**KIRKLEES METROPOLITAN COUNCIL
INVESTMENT & REGENERATION SERVICE**

DELEGATED DECISION TO DETERMINE APPLICATIONS FOR LISTED BUILDING CONSENT

Reference No:	2024/65/91206/W
Site Address:	Huddersfield Railway Station, St George's Square, Huddersfield, HD1 1JB
Description:	Listed Building Consent for alterations to existing station entrance to improve accessibility (within a Conservation Area)
Recommending Officer:	Sue Brooks

Image 11 – Proposed ramped access handrail (north elevation)

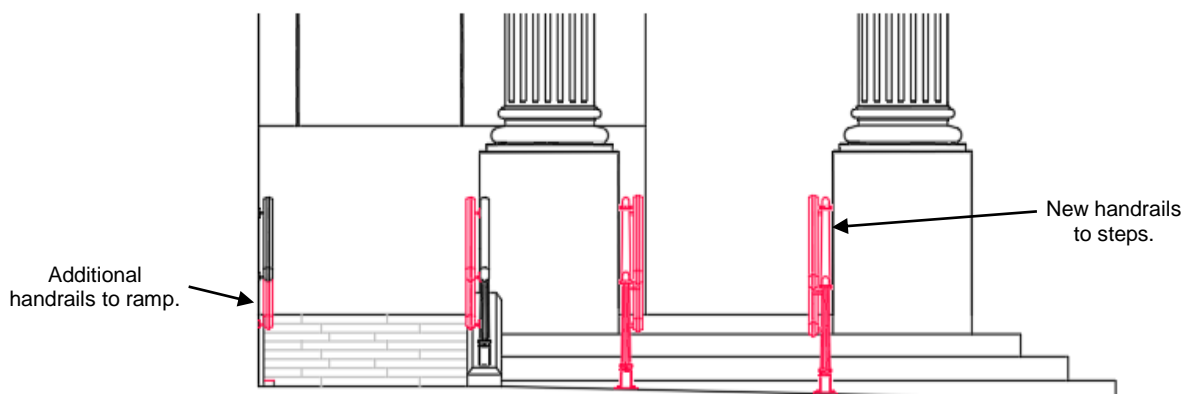
- Can the ramp handrail be fixed to the existing brackets to avoid further fixings into the wall of the building?
 - Response – this may be possible subject to loadings and details. To allow details to be provided, a condition will be applied requiring handrail details to be submitted for approval.
- How are the tactile strips secured in place?
 - These are secured by small fixings drilled into the stonework.

A 600mm high handrail is also proposed to the wall of the station building alongside the ramp and below the existing handrail, which is secured with 9 brackets. Brackets for the new handrail are proposed into the ashlar stonework, which will cause harm to the building fabric by securing additional fixings into the masonry. It was suggested that the existing handrail brackets could be adapted to support the new rail to reduce interventions into the masonry, and therefore a condition has been applied requiring details to be submitted for approval to allow the fixing details to be designed. The principle of providing a further handrail on this side is acceptable as it is a necessary intervention to provide safe access and the design matches the existing.

3. Notwithstanding the information submitted, the proposed handrail adjacent to the ramp and below the existing wall-mounted handrail, shall be fixed to the existing handrail bracket unless otherwise approved by the Local Planning Authority. Design and fixing details shall be submitted to and approved in writing by the Local Planning Authority prior to installation.

Image 14 – Existing entrance light fittings

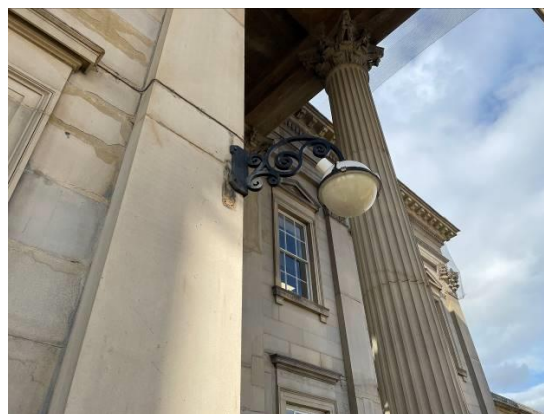
- Tactile strips with a brass finish were suggested instead of a stainless-steel finish.
 - This was agreed.
- Can the number of new external lights on the façade be reduced to reduce the impact on its architectural interest?
 - These will be reduced from four to two, with the new lights set behind the portico columns where they are less prominent rather than on the face of the building. If calculations show that the light level is insufficient, a variation of condition application will be submitted.

Improved external lighting is proposed to the entrance area, with the existing wall mounted globe lighting units restored, and two additional lights fixed to the front elevation of the station to improve visibility and safety where the level of illumination is poor at the sides of the portico, particularly for the access ramp and northern steps. Four new lights were originally proposed and following negotiations this was reduced to two lights set behind the portico columns at each side of the entrance.

The three existing globe light fittings are not historic, which is evidenced by marks on the walls indicating the position of previous fixings. However, they are traditional in design and their like for like replacement is accepted. The two proposed light fittings replicate the existing and are placed symmetrically on the façade, with one fixed to each pilaster on the main building behind the portico columns where they have no impact on the most visible ashlar elevations. Proposed fixing methods are the same as the existing fittings.

5. Notwithstanding the information submitted, bracket fixings and cable holes of the proposed external lights shall be kept to a minimum and no external cable runs shall be permitted.
